Rezoning Transportation Analysis

Petition Number: 2021-163

Date	Description
08-26-21	First Review (LH)
09-23-21	Second Review (BKB)
10-28-21	Third Review (BKB)

Uptown CycleLink 6th Street Cycle track and other streetscape enhancements along 7th Street. Site plan revisions are needed to meet outstanding items including, but not limited to:

1 - 7TH STREET SECTION A (W/ RIDESHARE/DROPOFF)  
SECTION

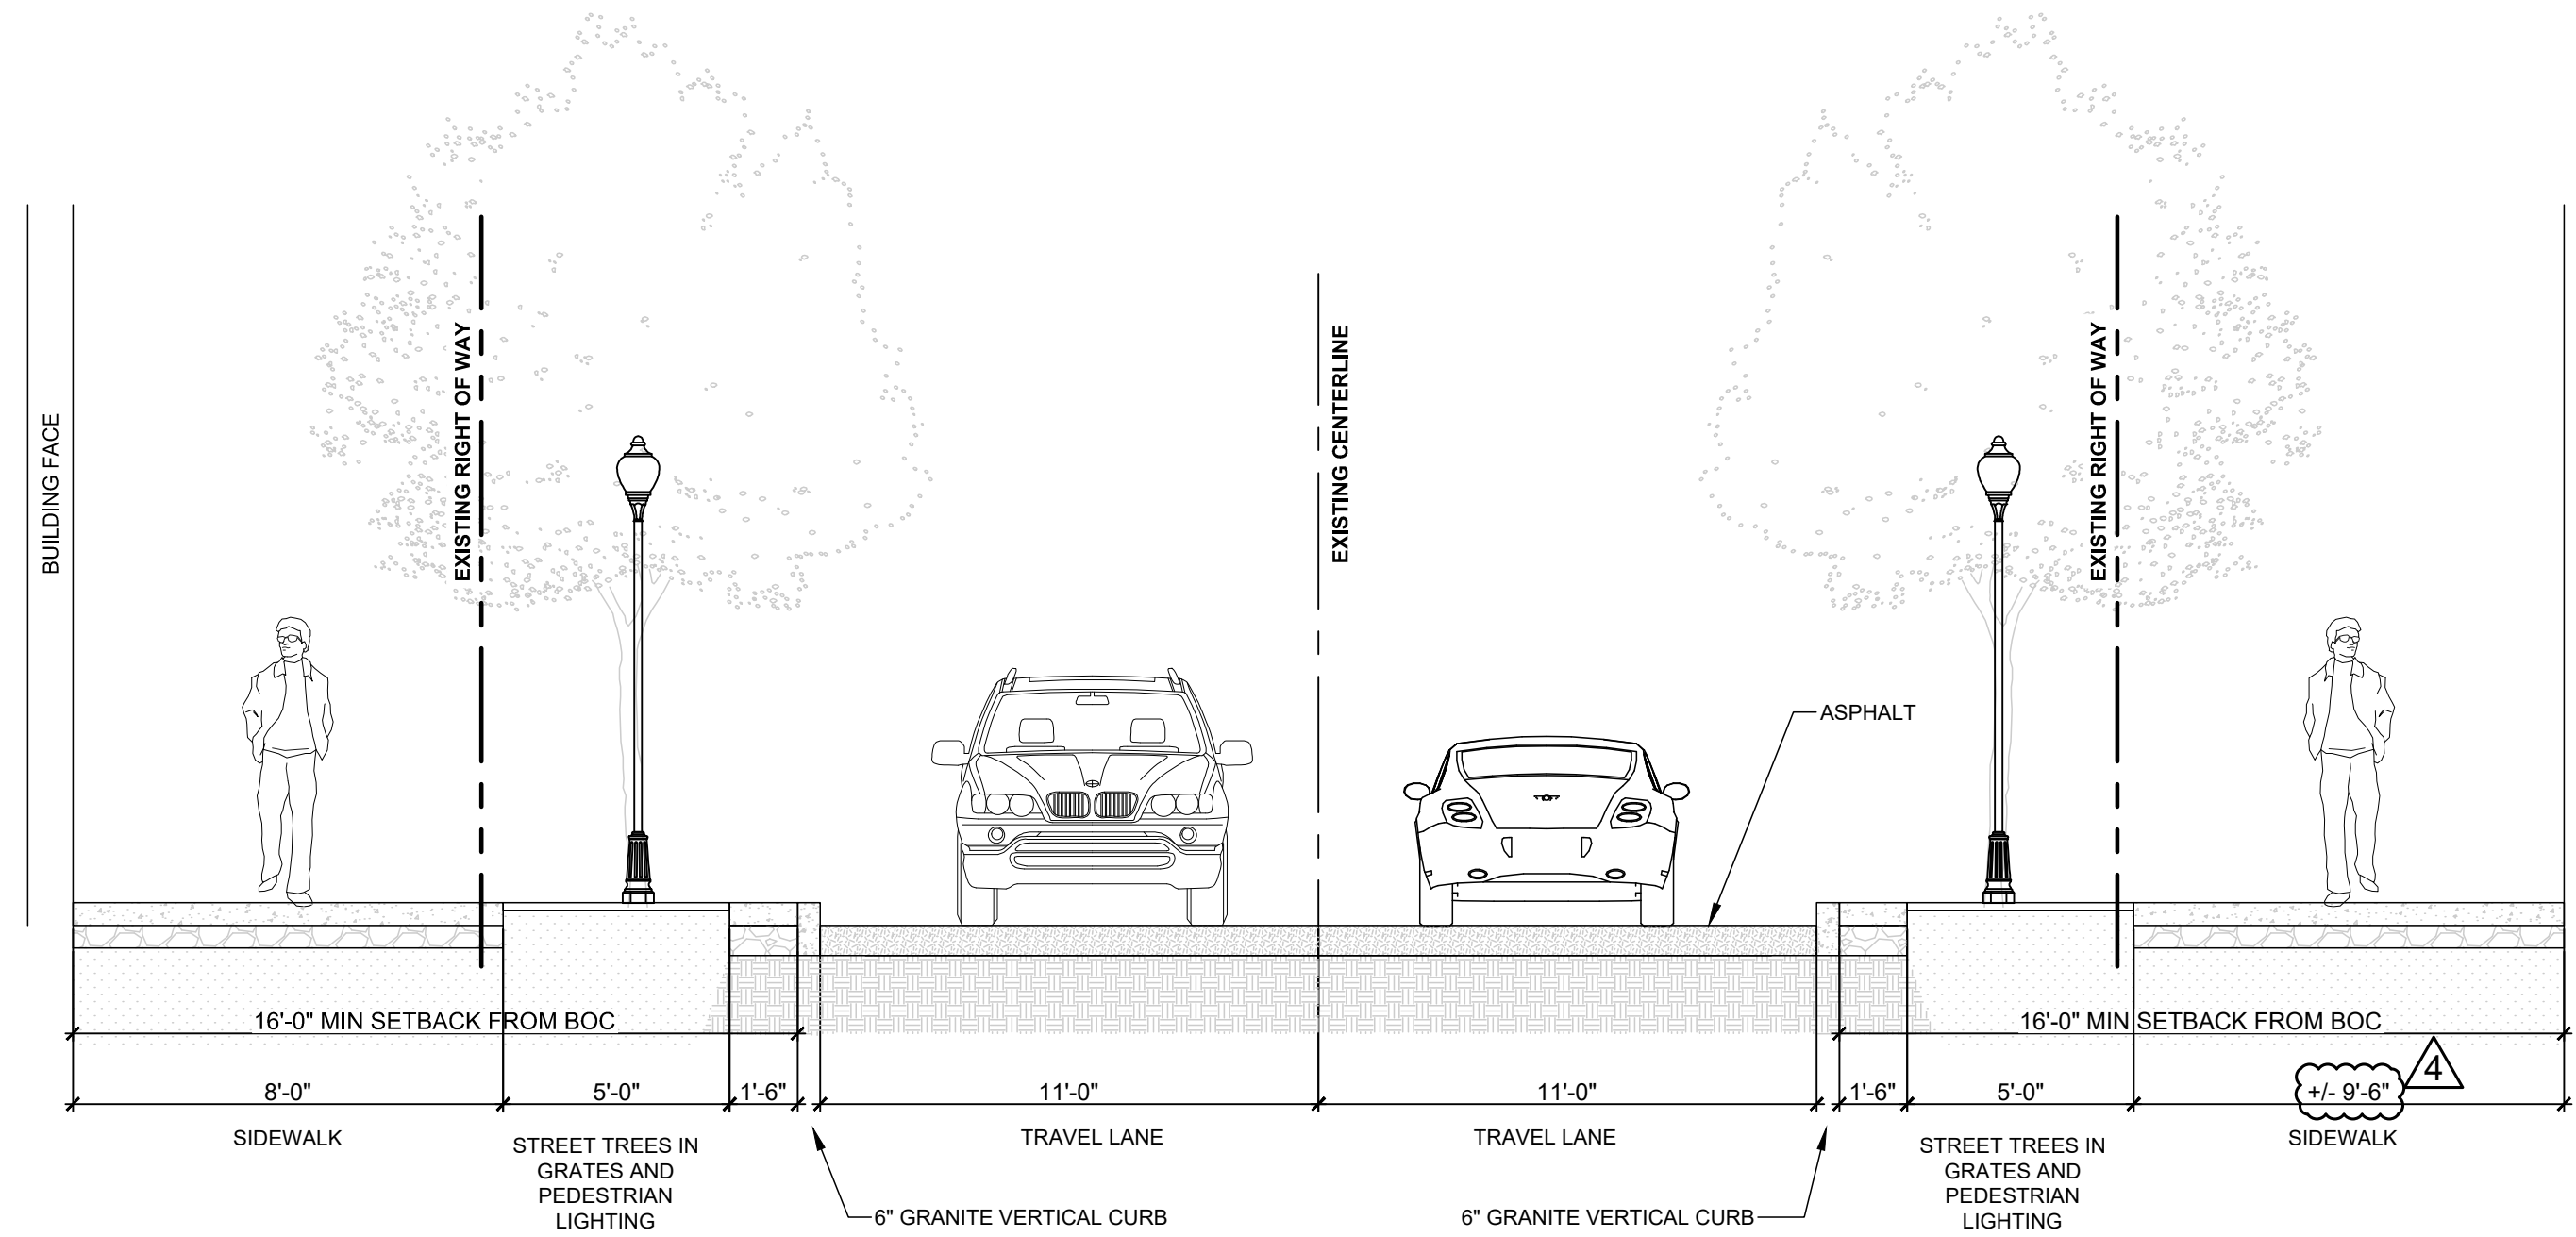
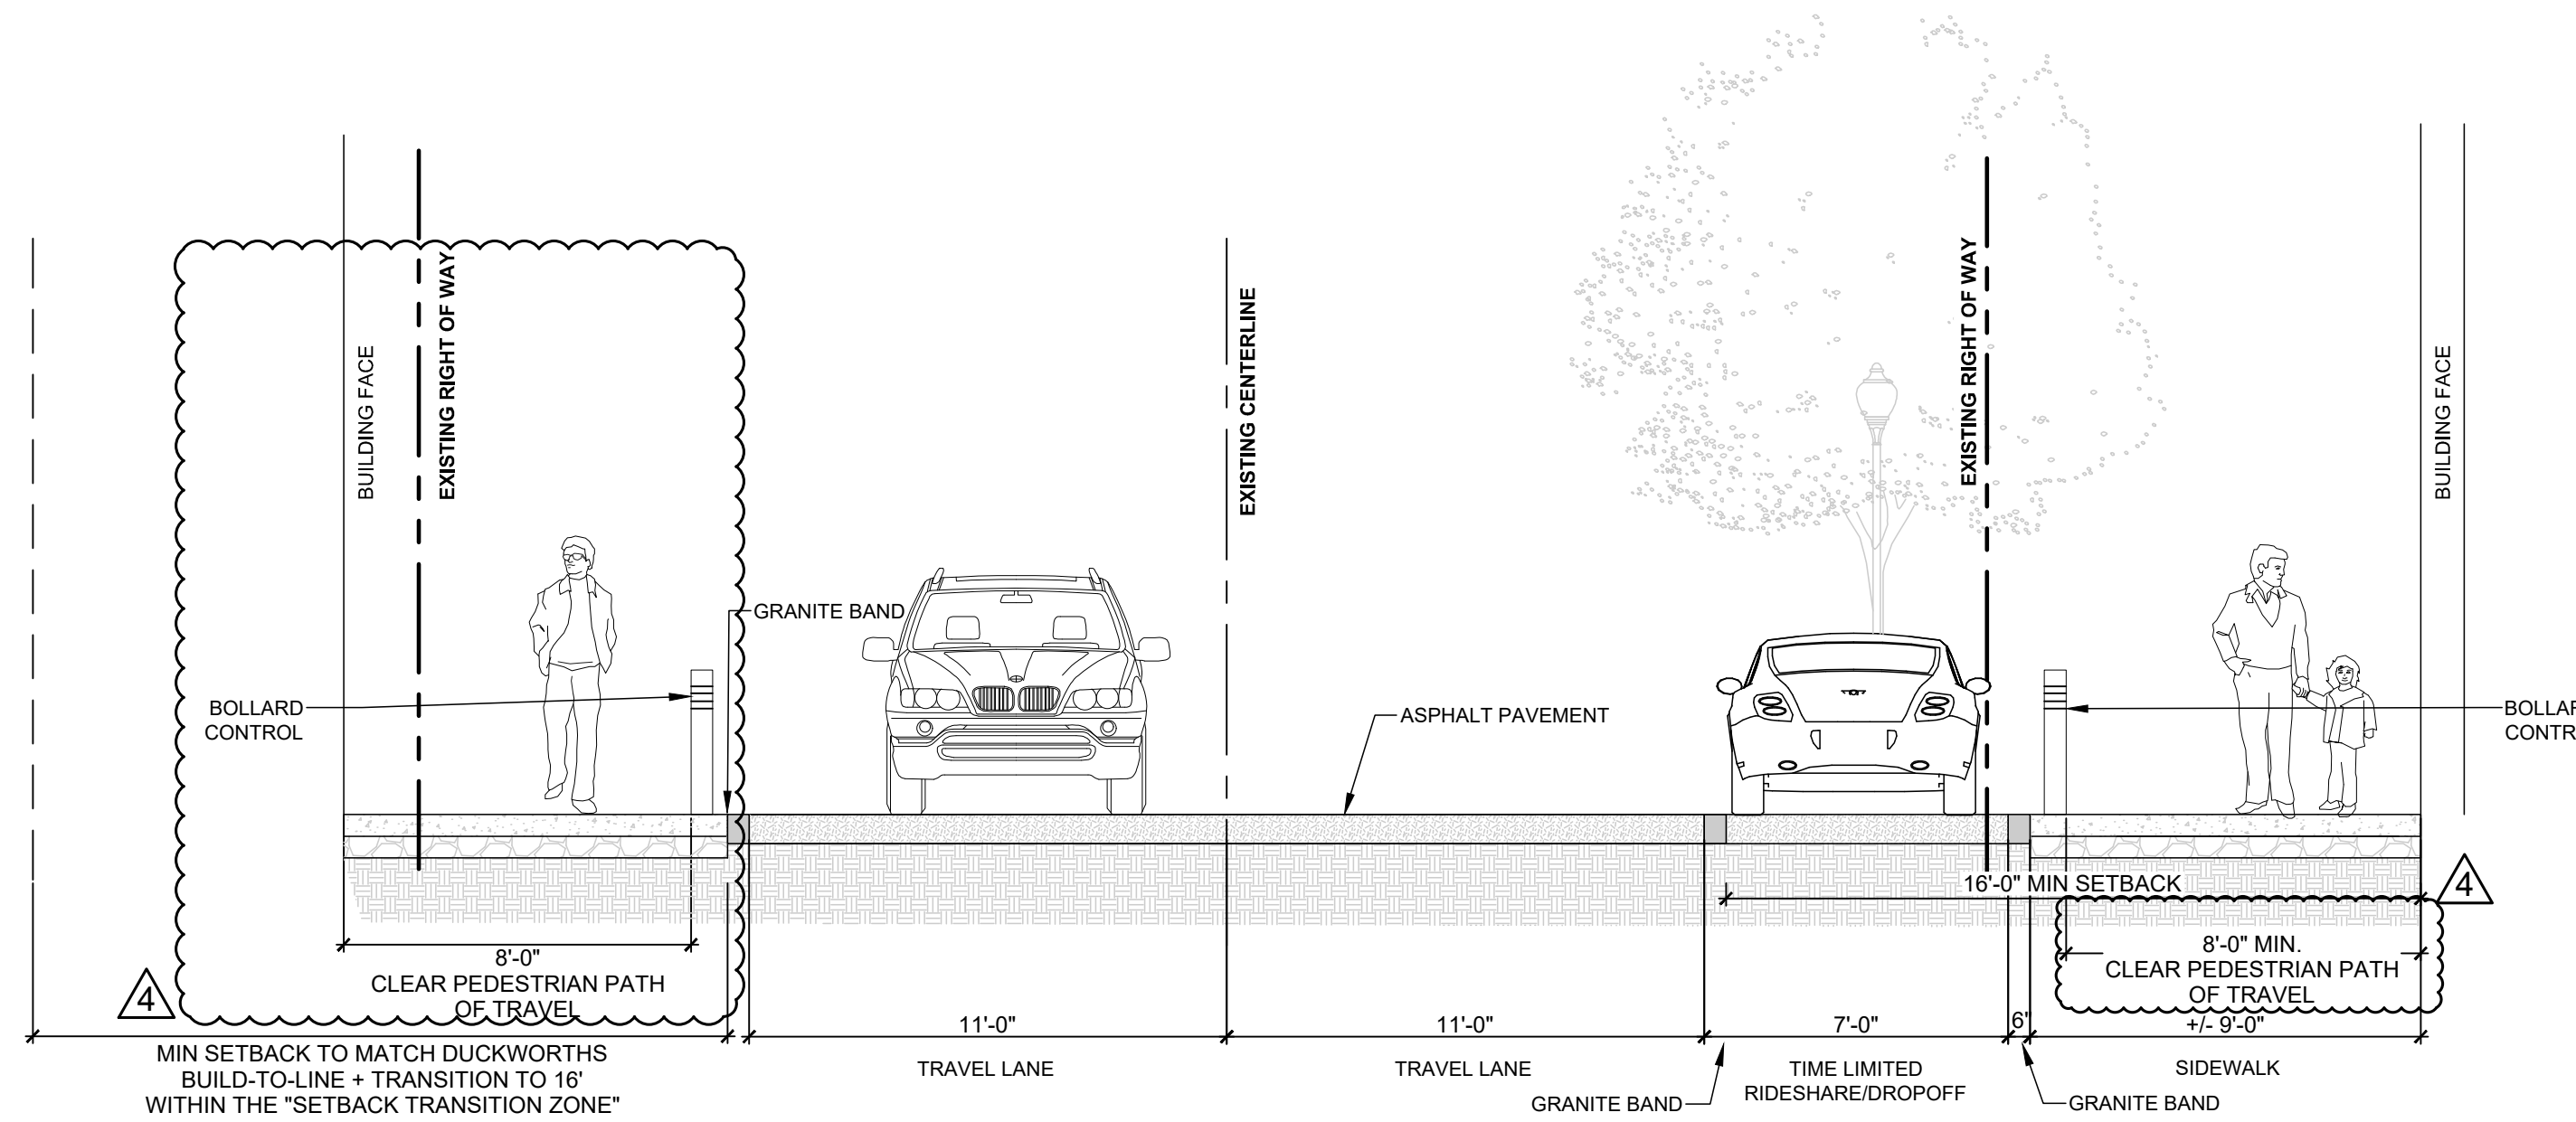
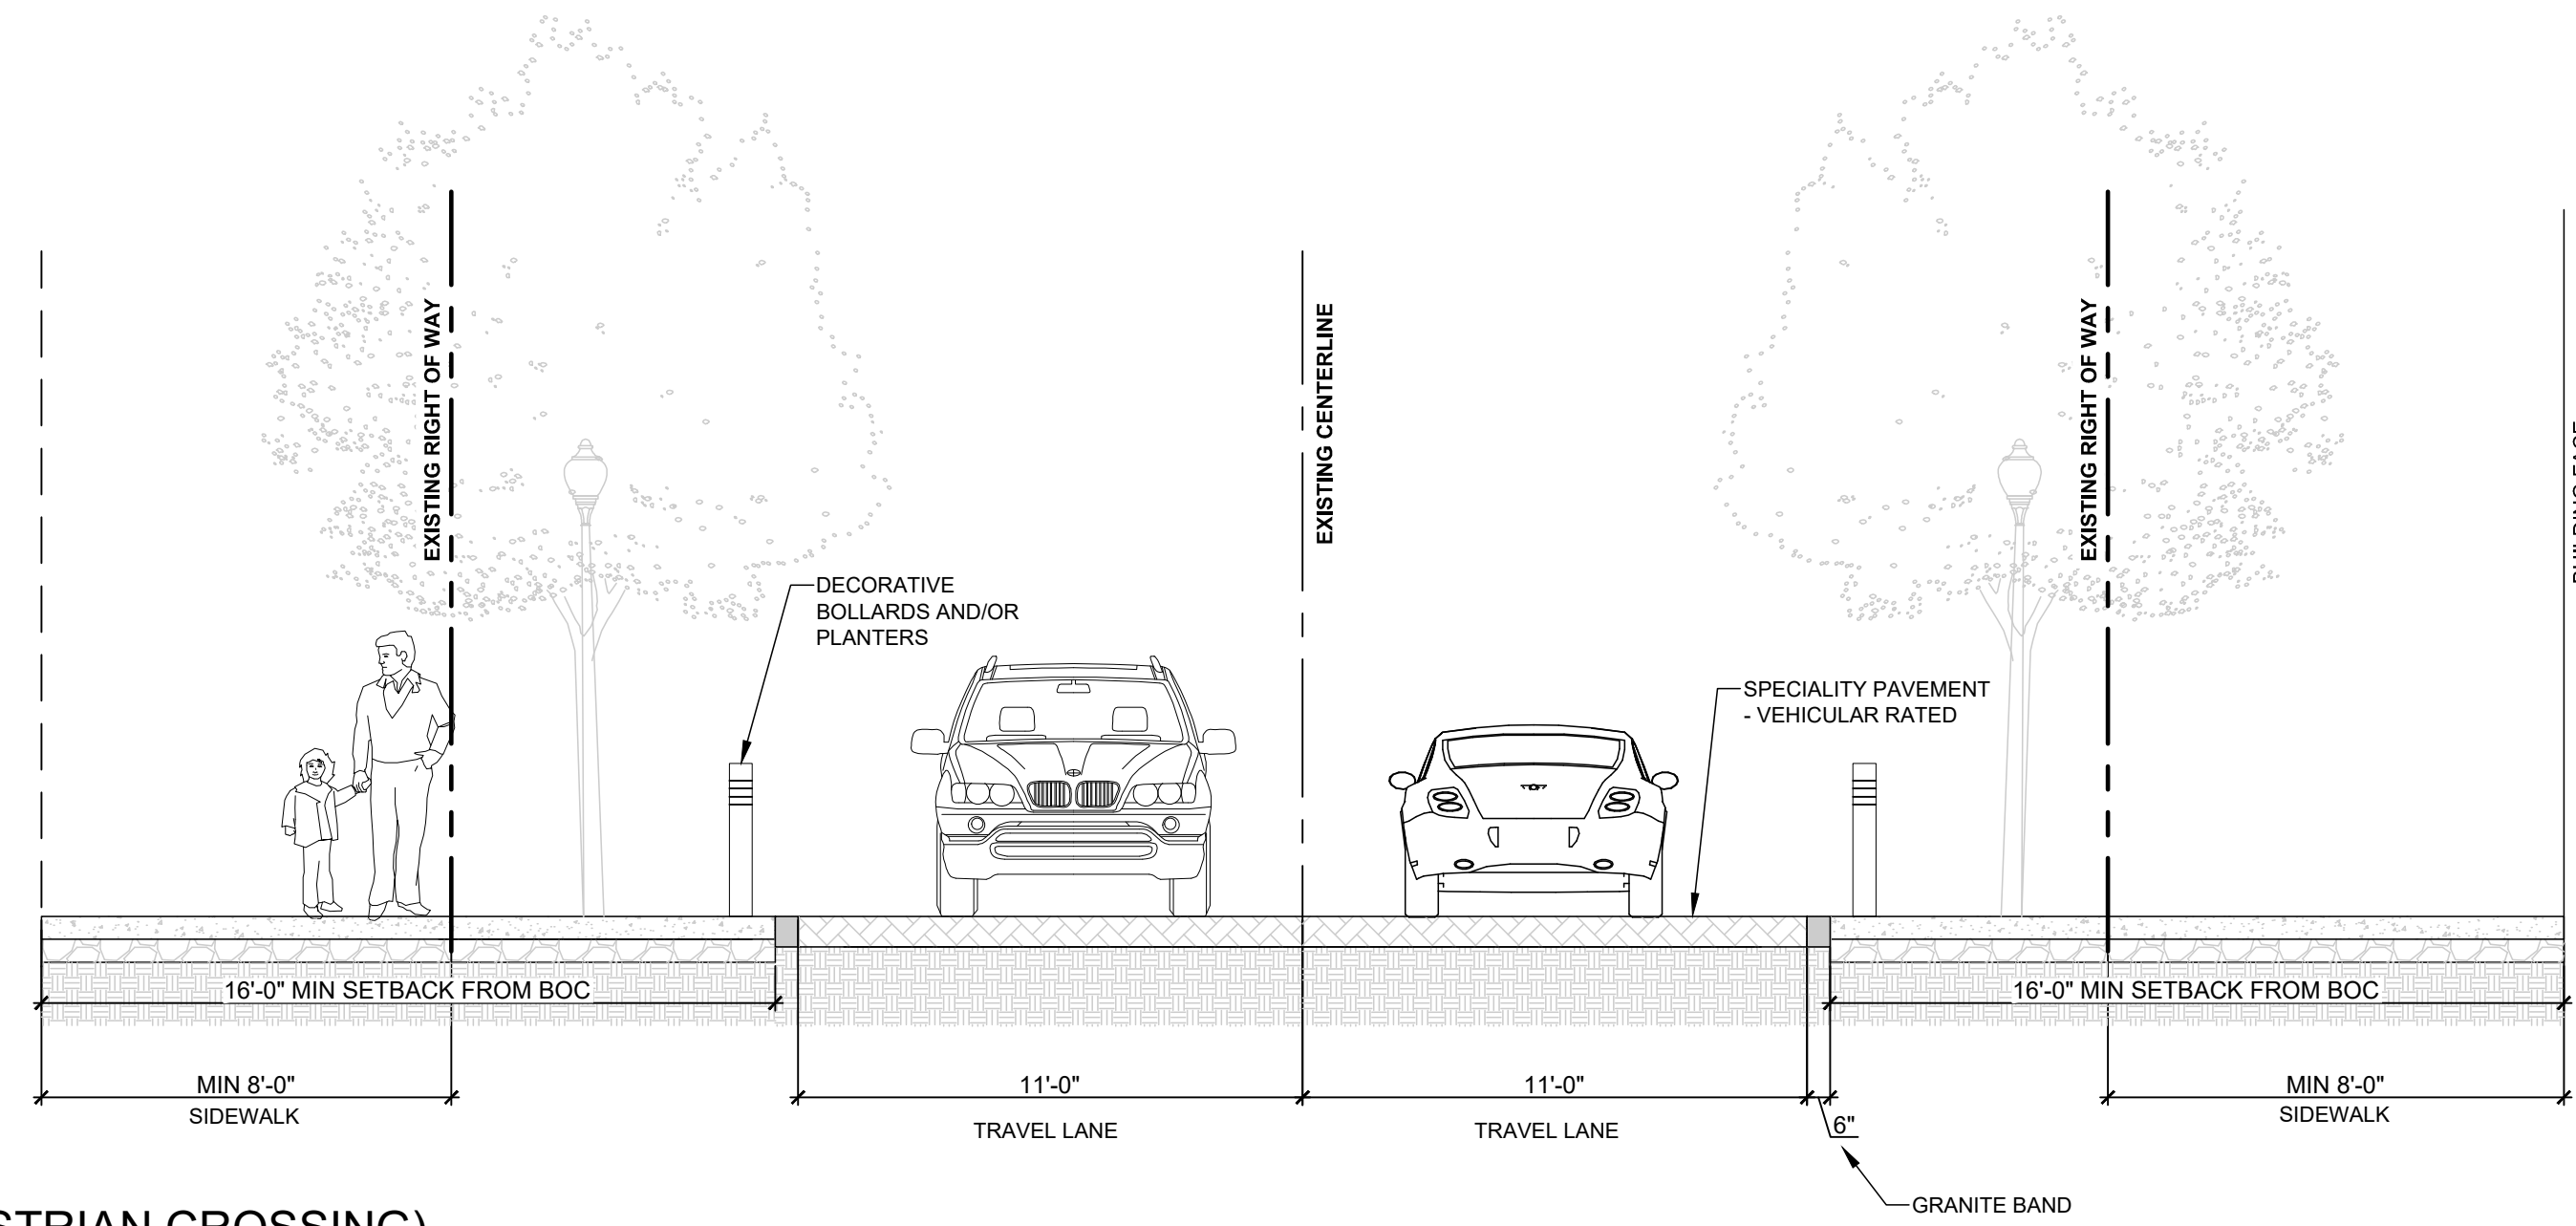
a. **Travel Lanes:** 10-foot travel lanes are not suitable for shuttles that would frequent the hotel or a GATS bus if 7th Street was used as a detour. Update travel lane adjacent to hotel to 10-foot, 6 inches minimum width. If using vertical curb, adjust for 11-foot travel lanes.

- b. ~~Curbless Street w/Bollards~~: Add a conditional note that states to confirm that PROWAG and drainage adjustments are accounted for during permitting. Place bollards as far away from travel lane as possible within the 1 foot, 6 inch flush granite curb. Show limits of bollards on site plan.
